Recommendation Report for Planning Permission for Works or Extension to a Dwelling

REF NO: R/88/22/HH

LOCATION: Chudleigh
The Close
Rustington
BN16 2DW

PROPOSAL: Erection of part single, part two storey rear and single storey front porch extension with terrace, hip to gable roof extension with solar panels and installation of timber cladding in place of hung tiles to bays.

P012 Proposed East and West Elevations

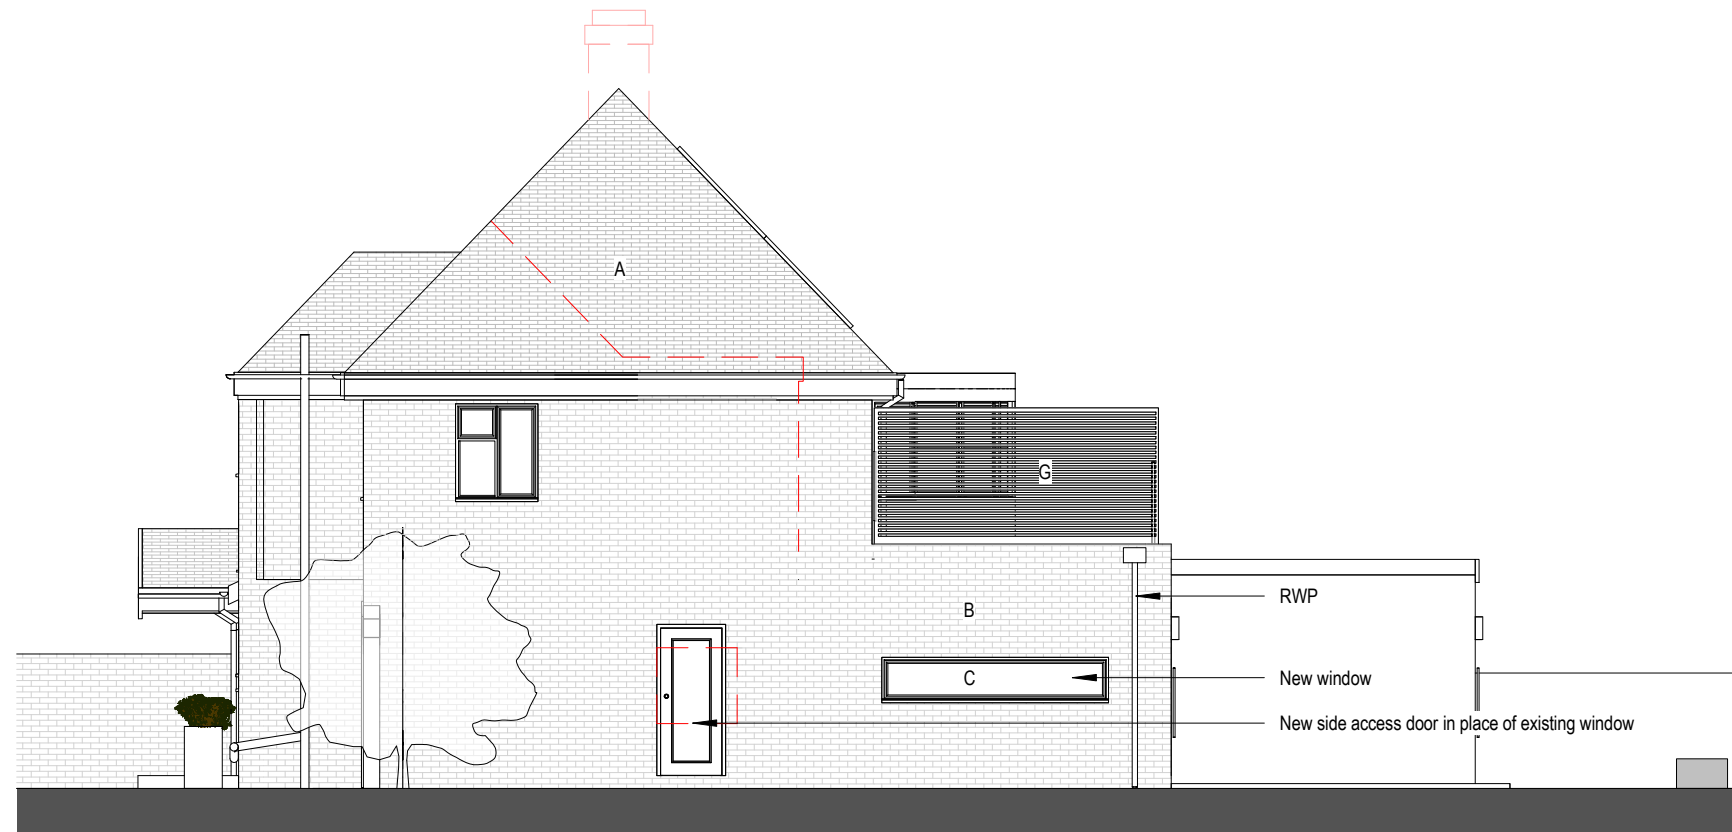
In addition to this it is proposed to add a hip to gable extension to the western elevation, which will affect the character of the building. The roof extension will not increase the ridge height or alter the eaves level, it will however encompass an existing portion of flat roof at first floor level. It is seen to give balance to the roof and incorporate less visually attractive parts of the existing structure. As such it will not negatively impact the character of the area and will be subservient to the host dwelling.

In terms of overlooking, new fenestration to be introduced at first floor level will face towards the rear private amenity space, where views are already achievable. A rear balcony is proposed, the two side facing elevations have been designed to have a minimum of 1.8m obscured screening. This is acceptable and will not negatively impact privacy levels to the properties to the east or west, a condition will be added to this approval to retain the screening in perpetuity.

- Location Plan P001
 - Proposed Ground Floor Plan P008
 - Proposed First Floor Plan P009
 - Proposed North and South Elevations P011
 - Proposed East and West Elevations P012
 - Proposed Block Plan P002
Reason: For the avoidance of doubt and in the interests of amenity and the environment in accordance with policy D DM1 of the Arun Local Plan.
- 3 The installation of side screening to the eastern and western faces of the approved balcony will be provided before the first use of the room and be built to a minimum height of 1.8m and shall be built using an fully obscured material, the screening shall remain at this minimum height and fully obscured in perpetuity.

Reasons In the interests of the amenities of the occupants of nearby properties in accordance with policies D DM1 of the Arun Local Plan.
- 4 **INFORMATIVE:** Statement pursuant to Article 35 of the Town and Country Planning (Development Management Procedure)(England) Order 2015. The Local Planning Authority has acted positively and proactively in determining this application by assessing the proposal against all material considerations, including planning policies and any representations that may have been received and subsequently determining to grant planning permission in accordance with the presumption in favour of sustainable development, as set out within the National Planning Policy Framework.
